Soils and Geology Report

Southern Rail Park Spur

Fountain, Colorado

June 2023

SOILS MAP
SOUTHERN RAIL SPUR
EL PASO COUNTY, COLORADO
FIGURE 2

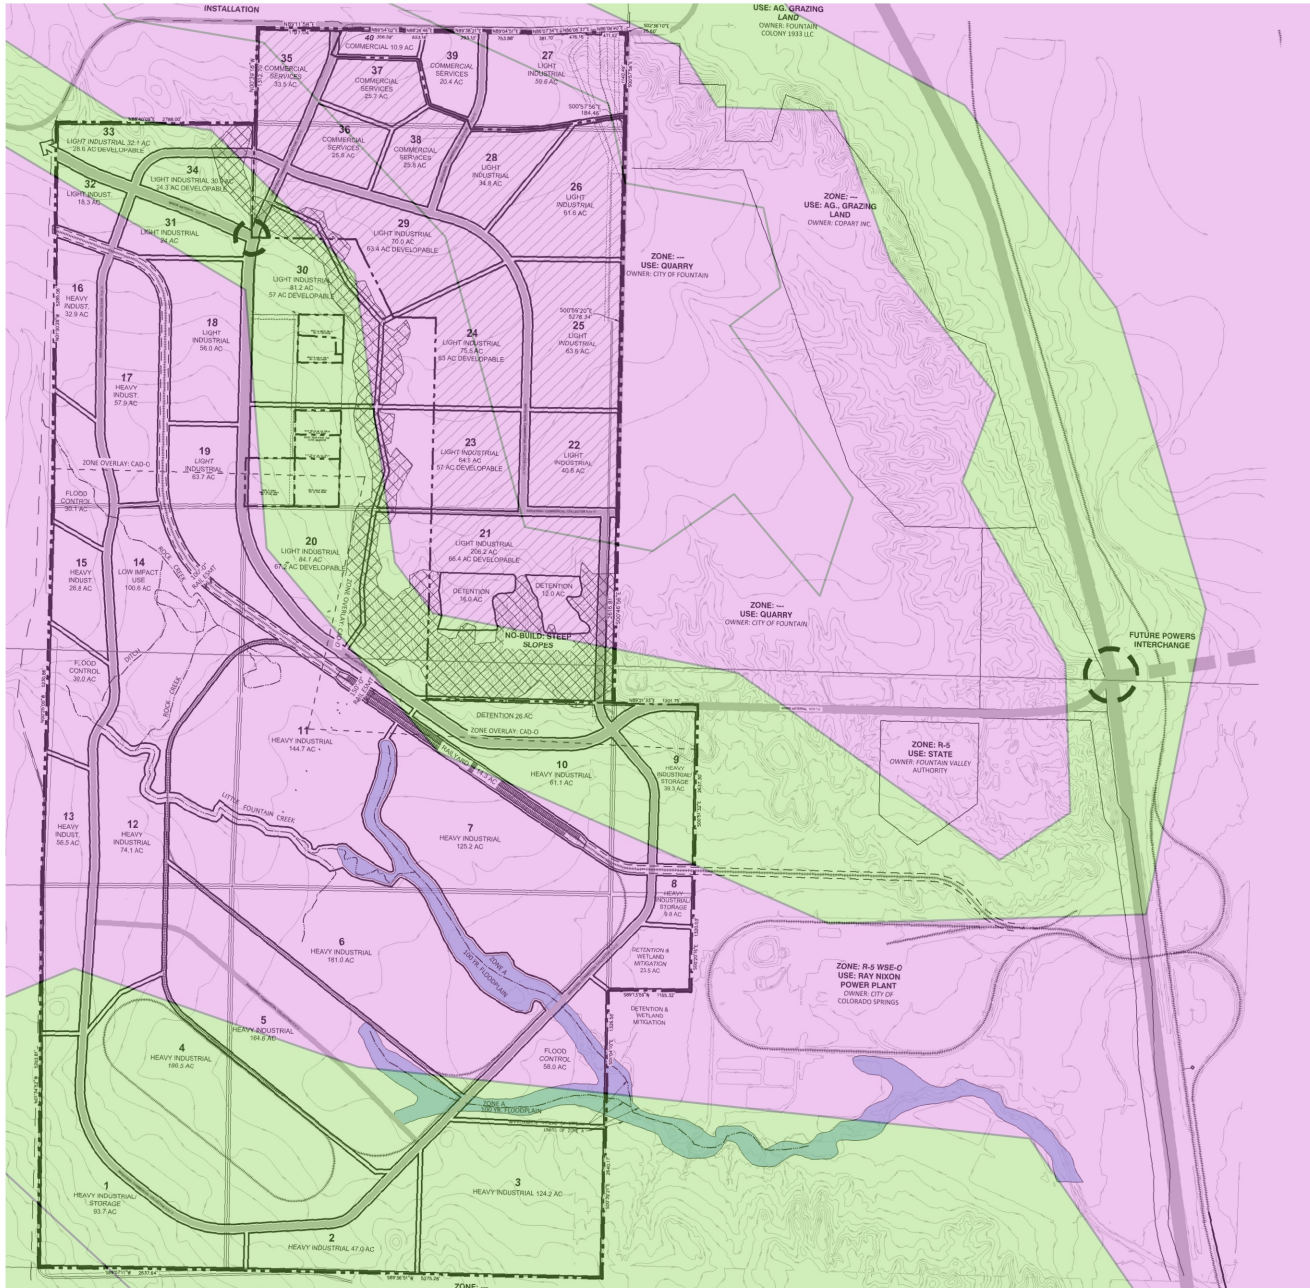
provide the names of the abbreviated types-
focus on the SKP area so its legible

GEOLOGIC MAP
SOUTHERN RAIL SPUR
EL PASO COUNTY, COLORADO
FIGURE 3

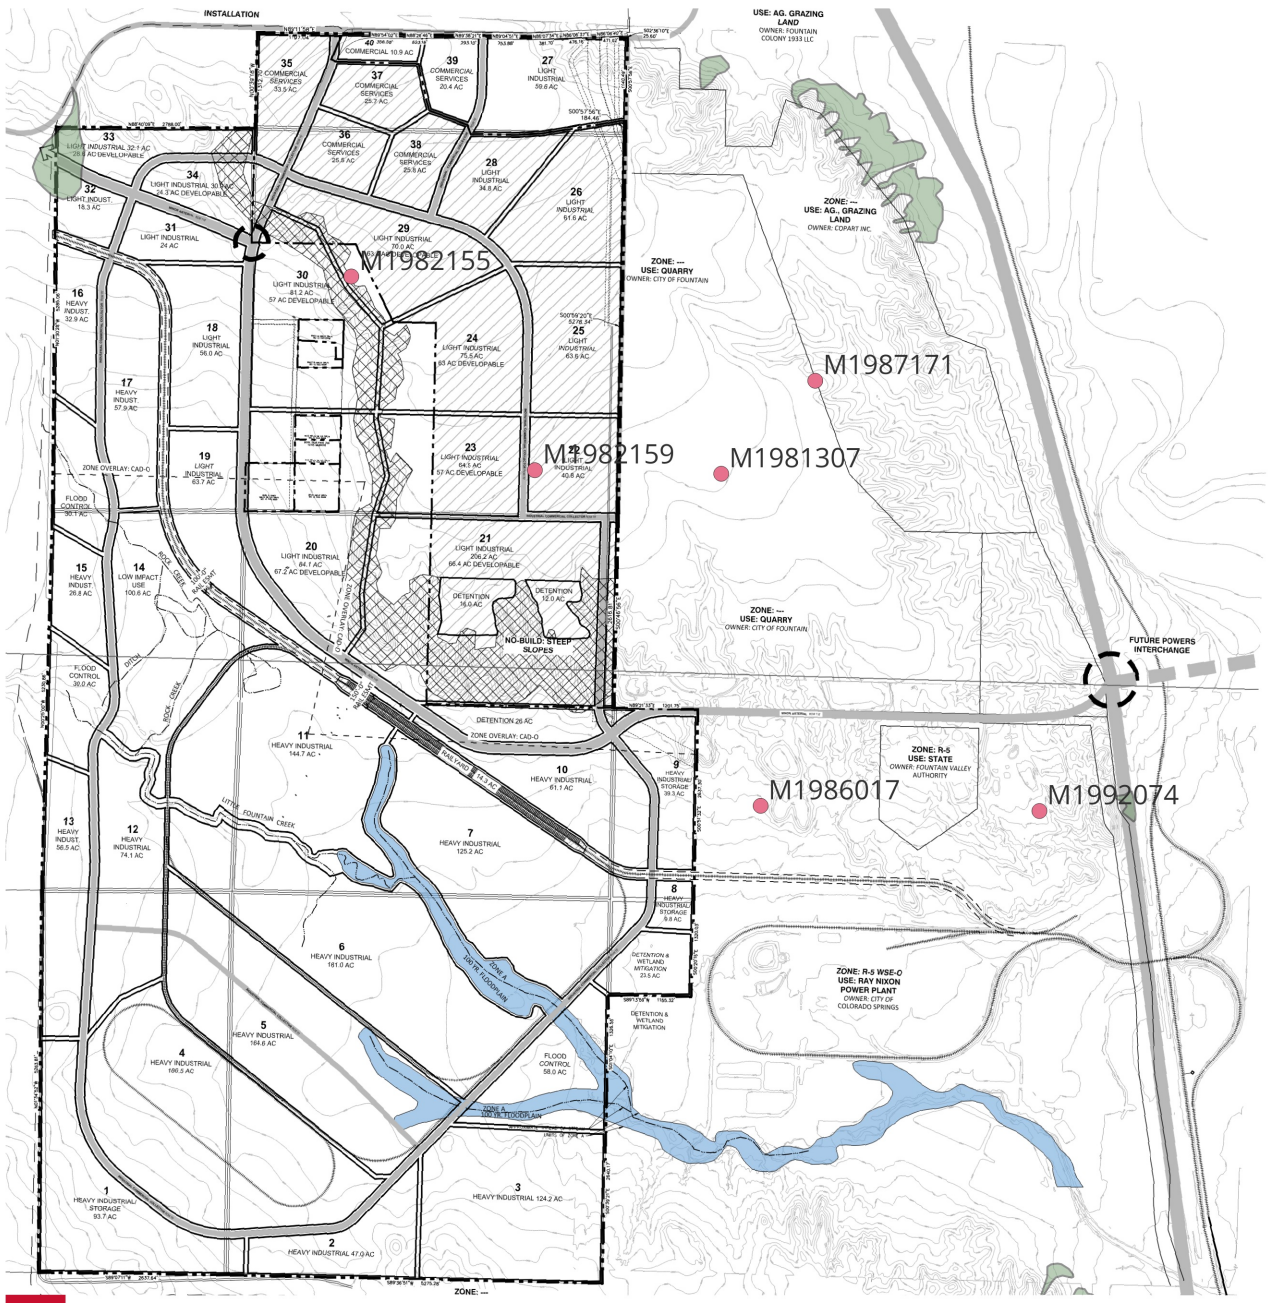
How are these not a hazard?
 please map on SKP and identify mitigation
